Appeal Decision

Appeal Ref: APP/R4408/W/15/3028022

Thurlstone House, Towngate, Thurlstone S36 9RH

- The appeal is made under section 78 of the Town and Country Planning Act 1990 against a refusal to grant outline planning permission.
 - The appeal is made by Ms Helen Smith against the decision of Barnsley Metropolitan Borough Council.
 - The application Ref 2014/1160, dated 29 September 2014, was refused by notice dated 20 January 2015.
 - The development proposed is a new dwelling within garden curtilage including a double garage.
-

REVISED ENTRANCE TO THURLSTONE HOUSE 1/2015 REF 2014/1160 1:100 SCALE

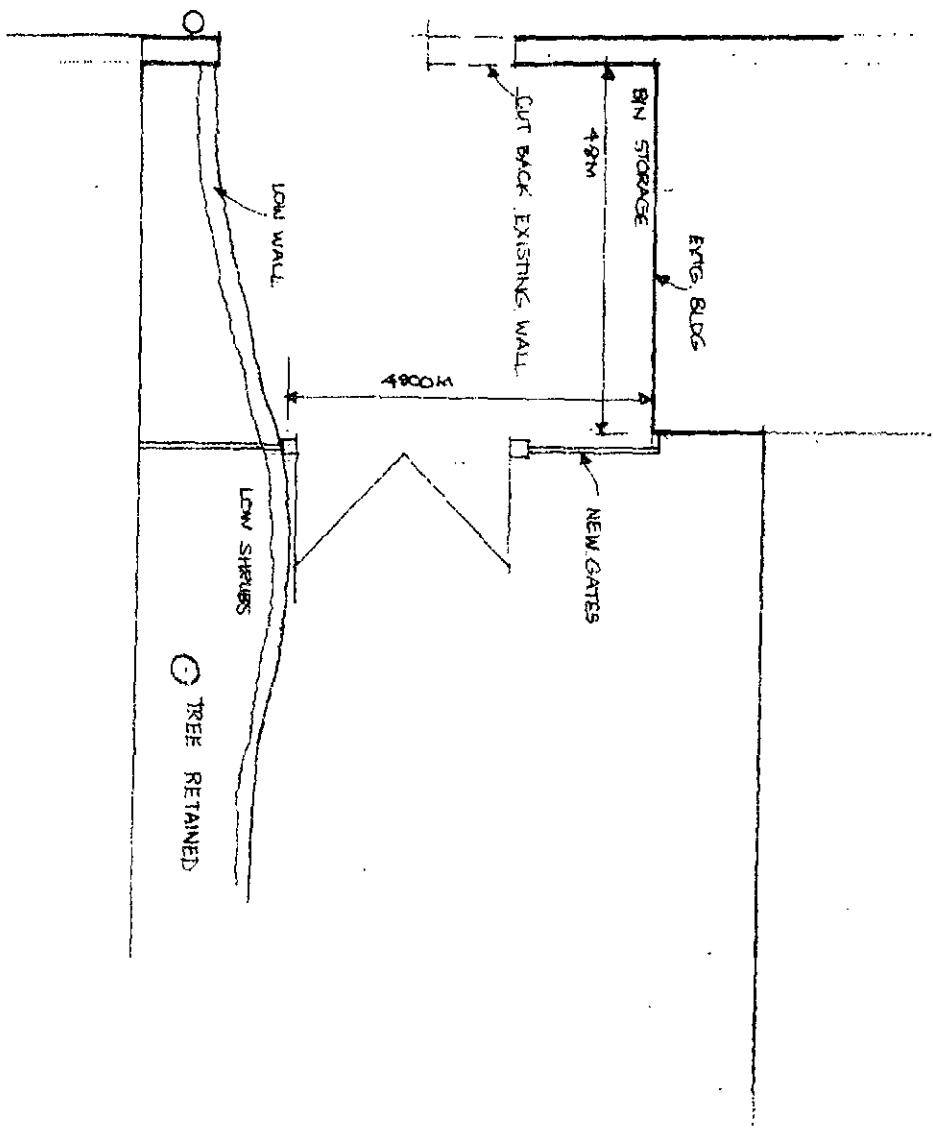
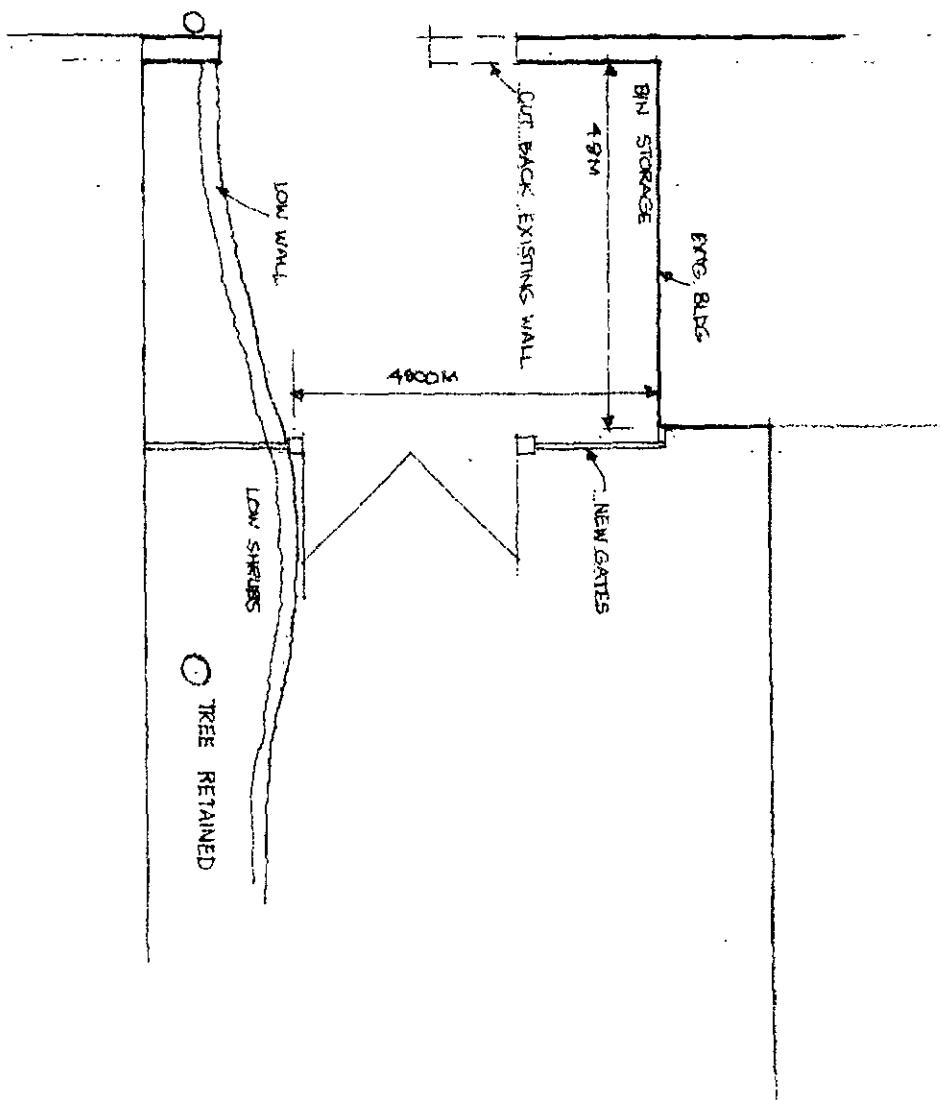
10. The proposal would be sited to the rear of the main elevation of Thurlstone House. Although layout is a reserved matter, indicative plans show separation distances of around 60m to the appeal site. The proposal would be accessed via the existing vehicular opening onto Towngate, with the creation of a long private drive around 60m in length, running parallel to the shared boundary with 11 and 11a Towngate.

11. The proposed driveway would pass closely to a kitchen window in the ground floor side elevation of Thurlstone House, as well as its main garden area. The driveway would also directly abut the gable ends of 11 and 11a Towngate, as well as the side boundaries of their outdoor space. Although there are no windows in the side elevation of those properties, vehicles would pass in close proximity to the main windows found in the rear of both properties, as well as their outdoor seating areas.

13. I recognise that vehicular movements from a single dwelling would be relatively low. Nevertheless the element of driveway closest to the neighbouring properties is that closest to the main road, where vehicles would be stationary for a time when exiting the site. In addition, vehicles would manoeuvre into and out of the site in close proximity to Thurlstone House and No 11. As a result, the noise from those vehicular movements, generated in close proximity to the neighbouring properties would likely cause an unacceptable level of disturbance to the occupiers of those properties.

PROPOSED DWELLING AT THURLSTONE HOUSE ELEVATIONS AND LOCATION DRAAI
9/14 1:100

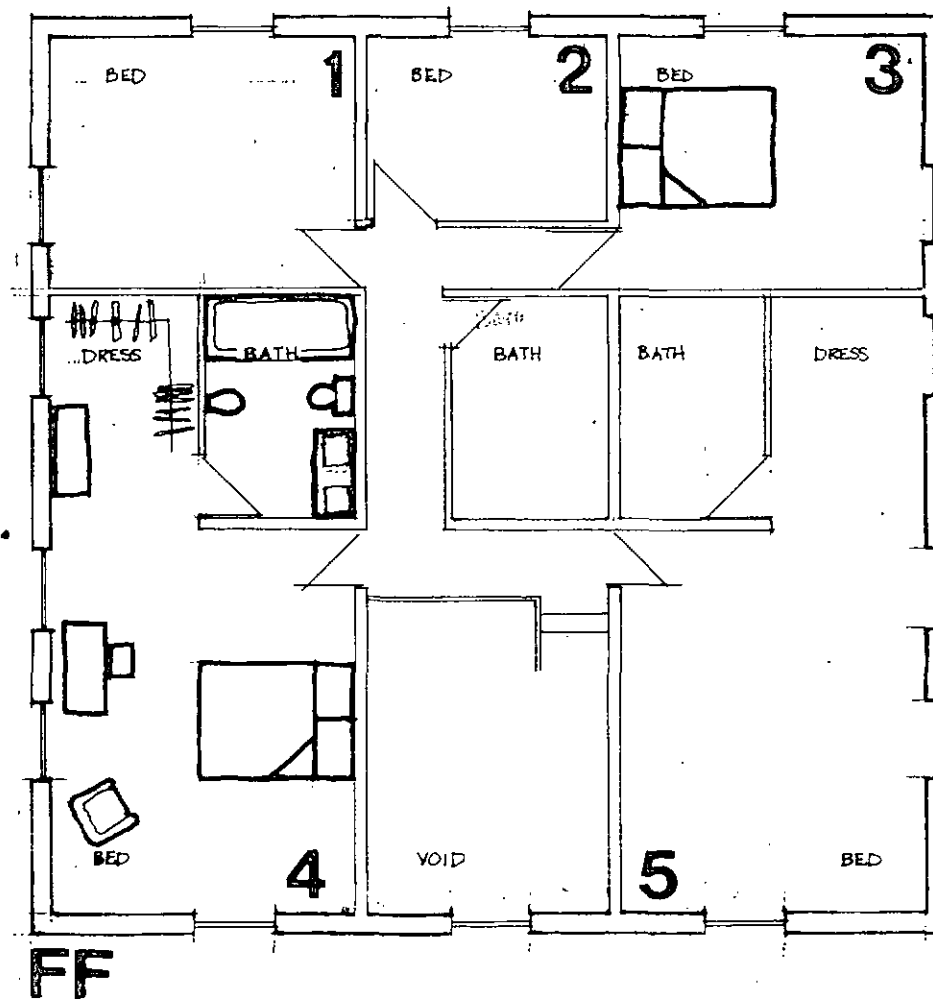
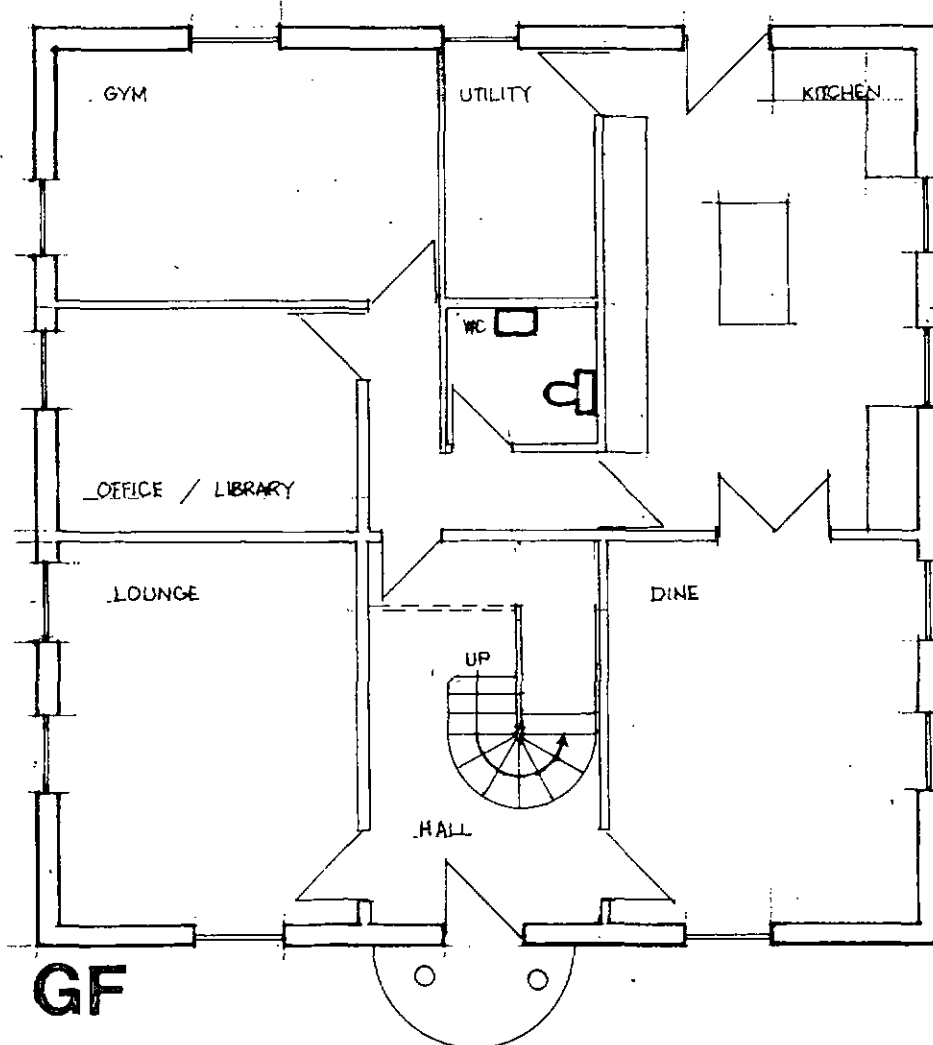
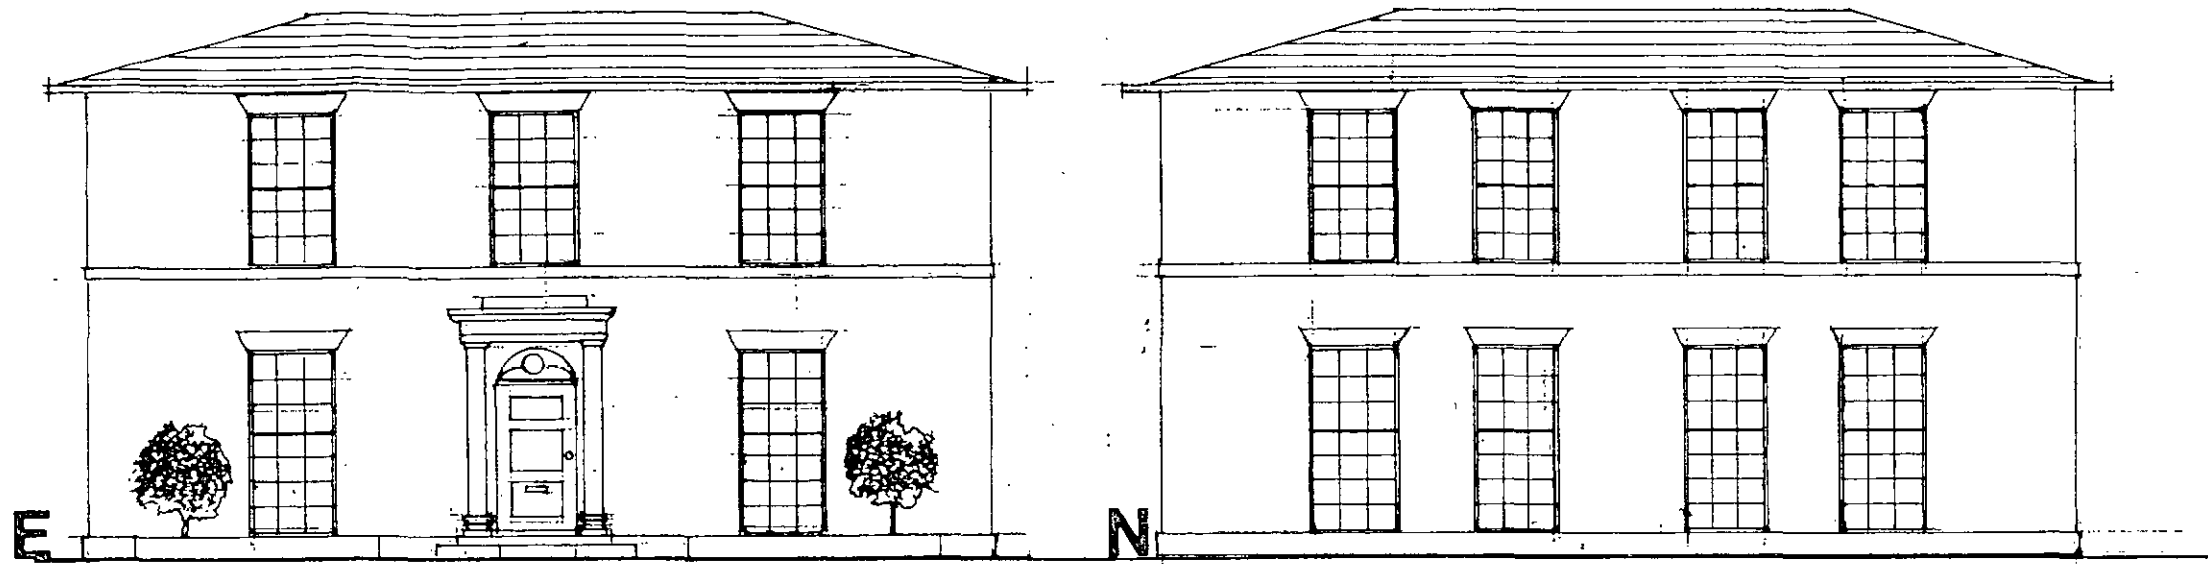
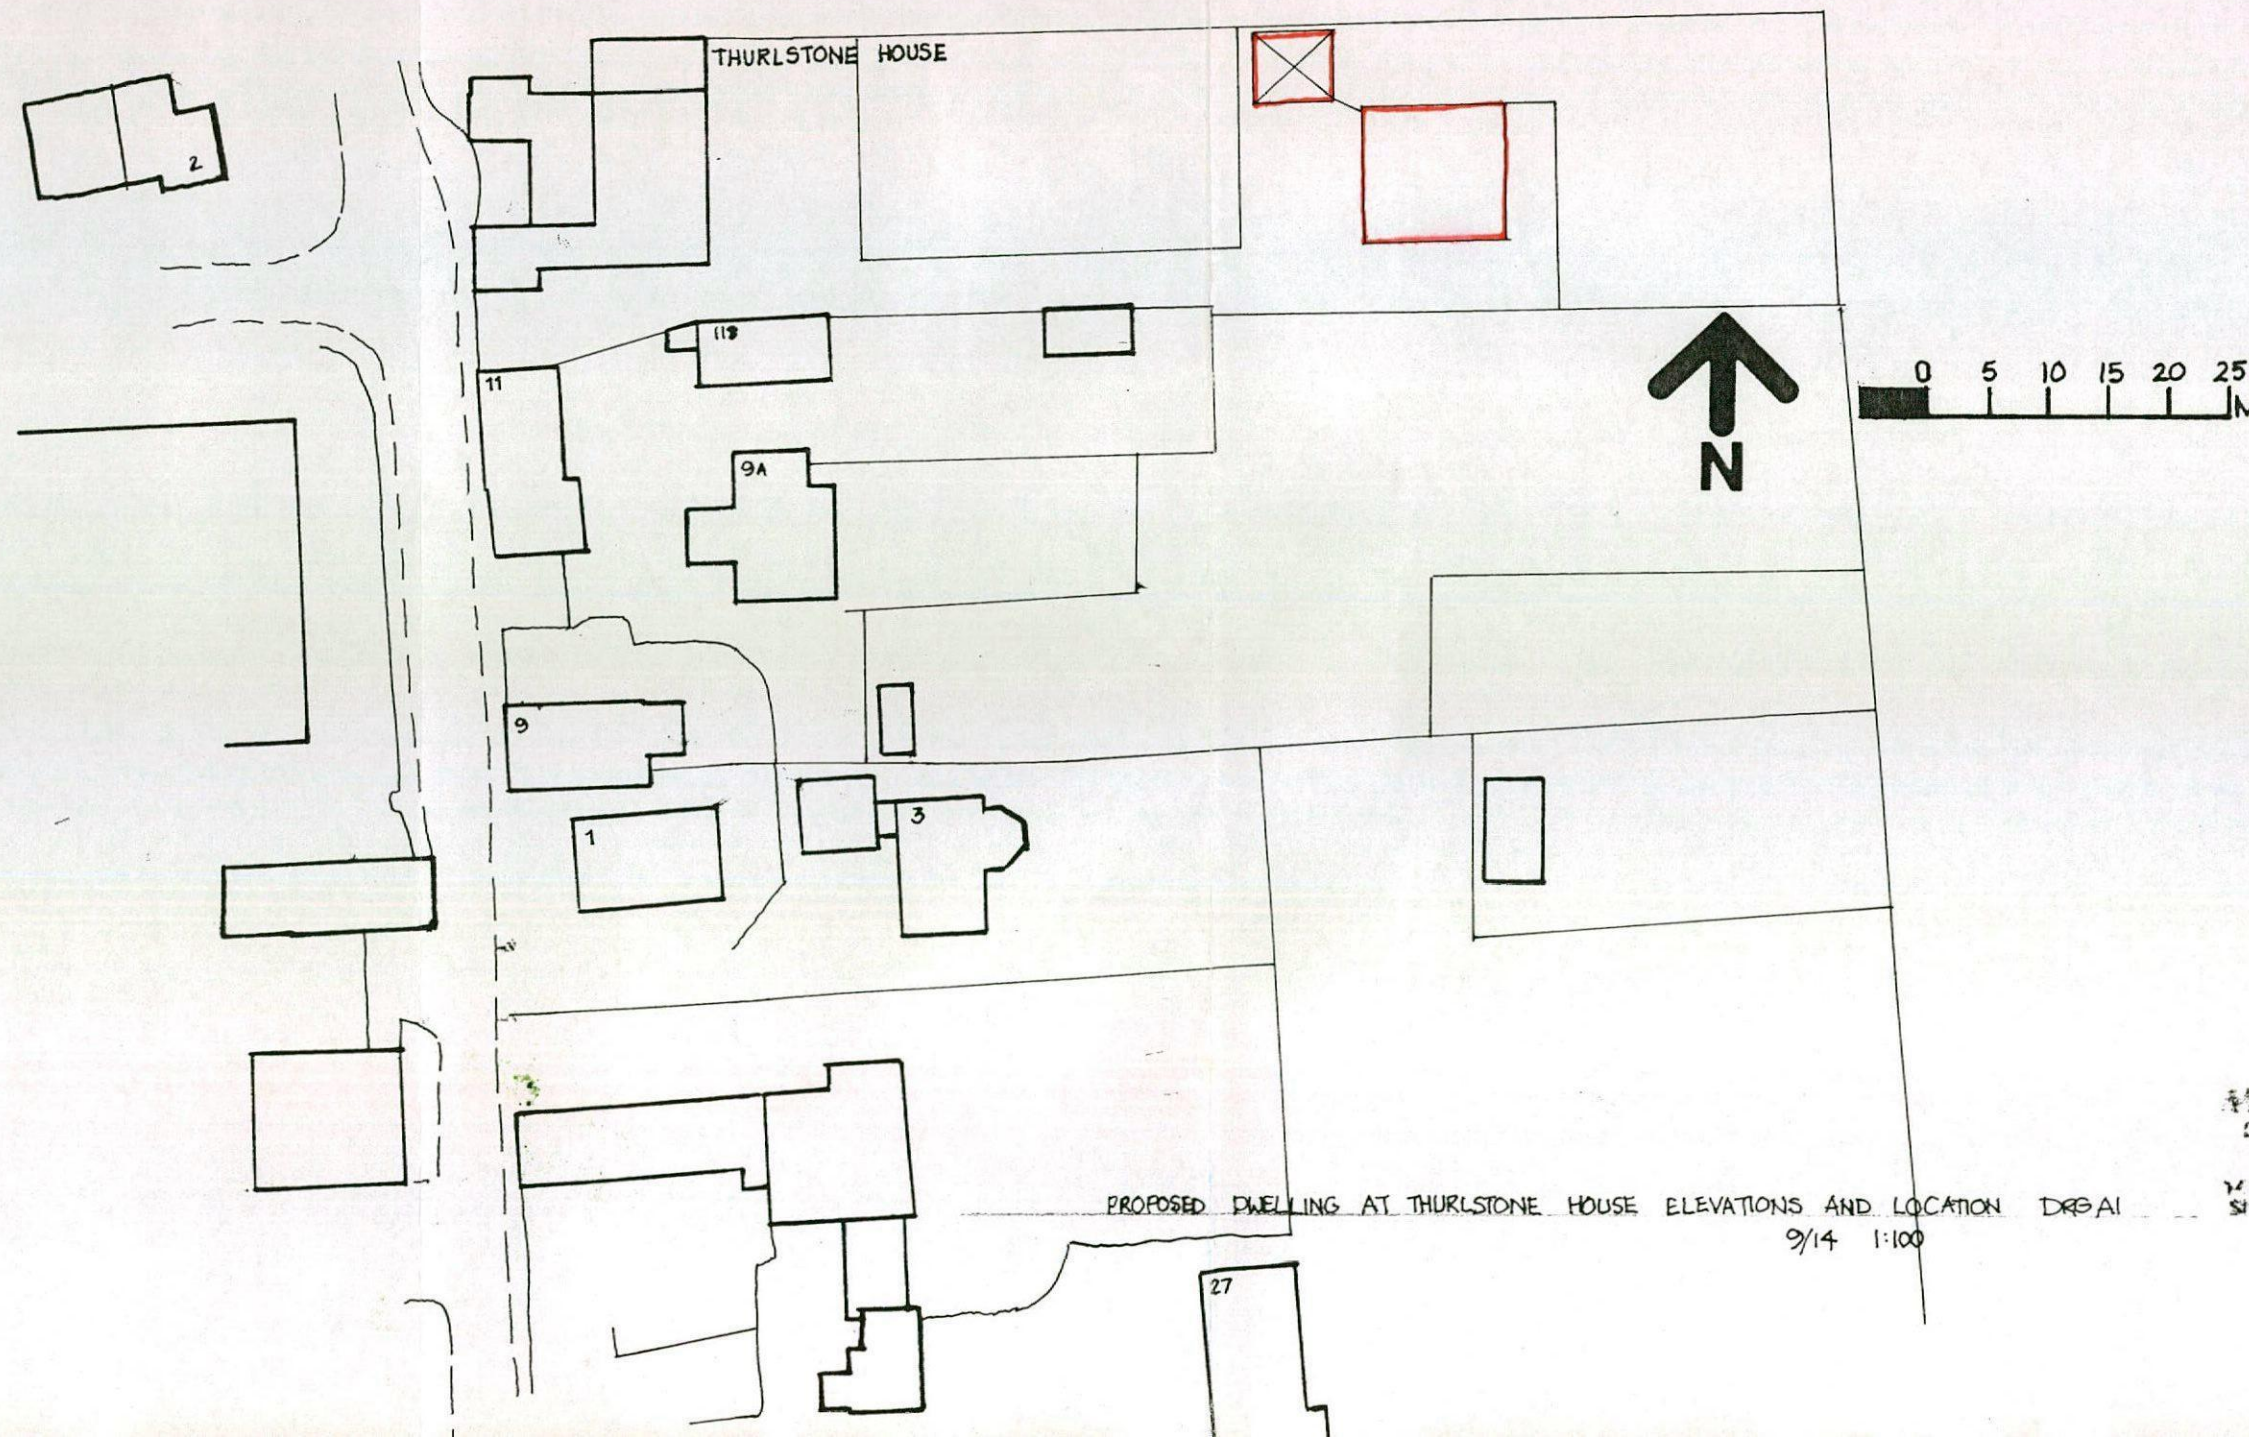
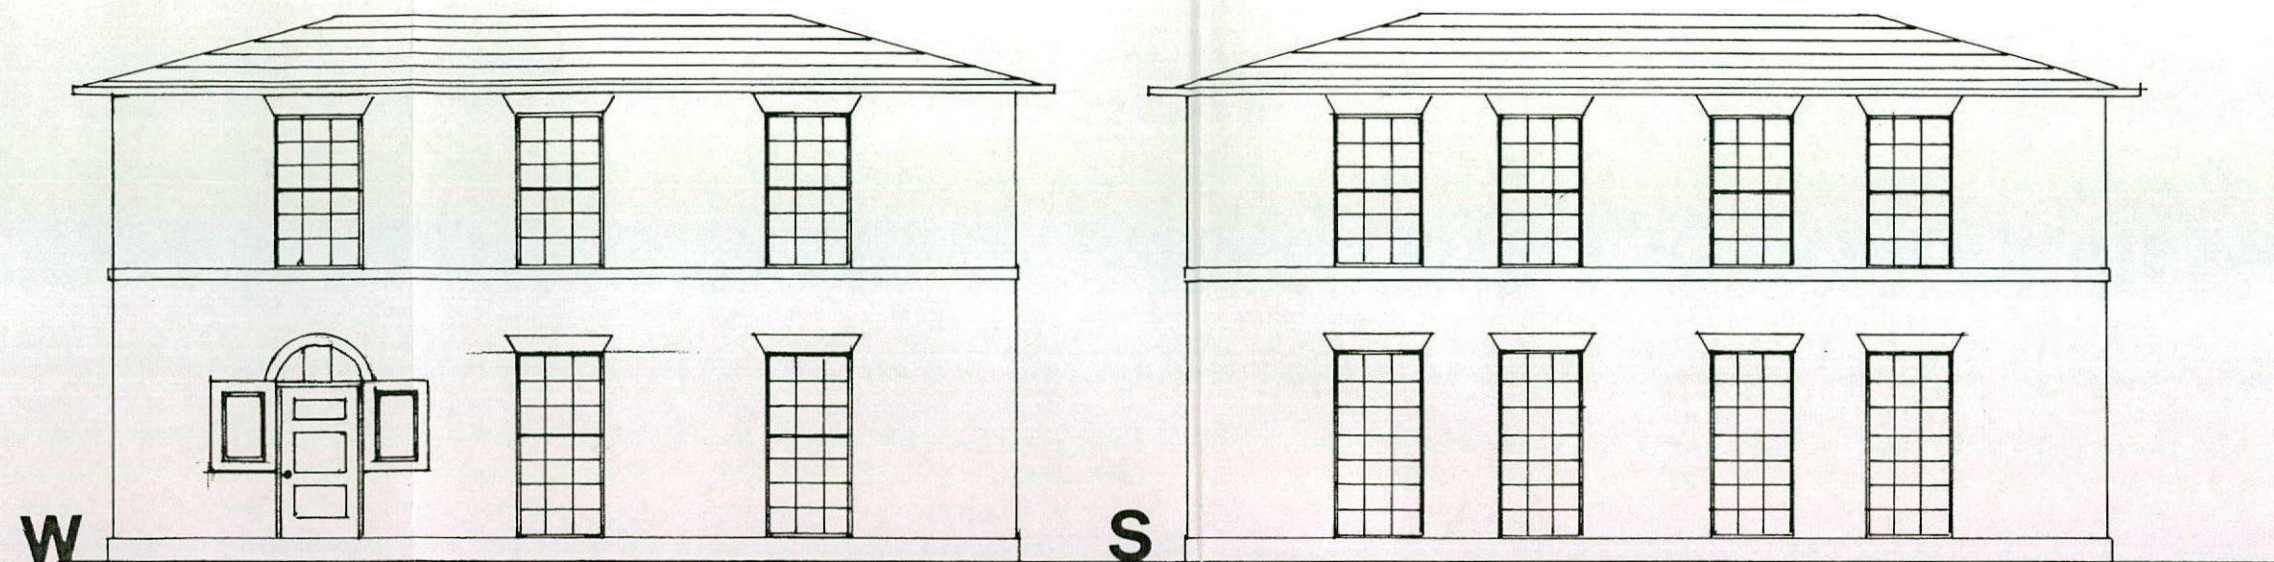
5. The appeal proposal would result in the provision of a large, two-storey detached dwelling within the rear garden of Thurlstone House. I note that the Council have raised no concerns with the indicative design or appearance of the proposal. However, the overall height and scale of the dwelling would present a significant incursion into the rear garden of Thurlstone House, eroding the expansive nature of the grounds. It would create an incongruous feature in this part of the conservation area, resulting in a significant built presence within an otherwise open and expansive area to the rear of the properties on Towngate. Whilst there are other examples of buildings behind the frontage, they generally appear as subservient outbuildings. The appeal proposal would, in contrast, appear as a dominant and obtrusive presence.

6. I note there are dwellings along The Green which run perpendicular to Towngate and extend behind the frontage. However, they provide a sense of disparity, acting as a marker as Towngate turns north-west and the consistency in the overall pattern begins to diminish. In contrast the proposal would introduce a dwelling set back significantly from the frontage which would fail to respond to the compacted nature of the built form fronting onto Towngate.

7. As a result, the proposal would fail to preserve or enhance the character and appearance of the Thurlstone Conservation Area, in conflict with the design and heritage aims of policies CSP29 and CSP30 of the Barnsley Local Development Framework Core Strategy 2011.
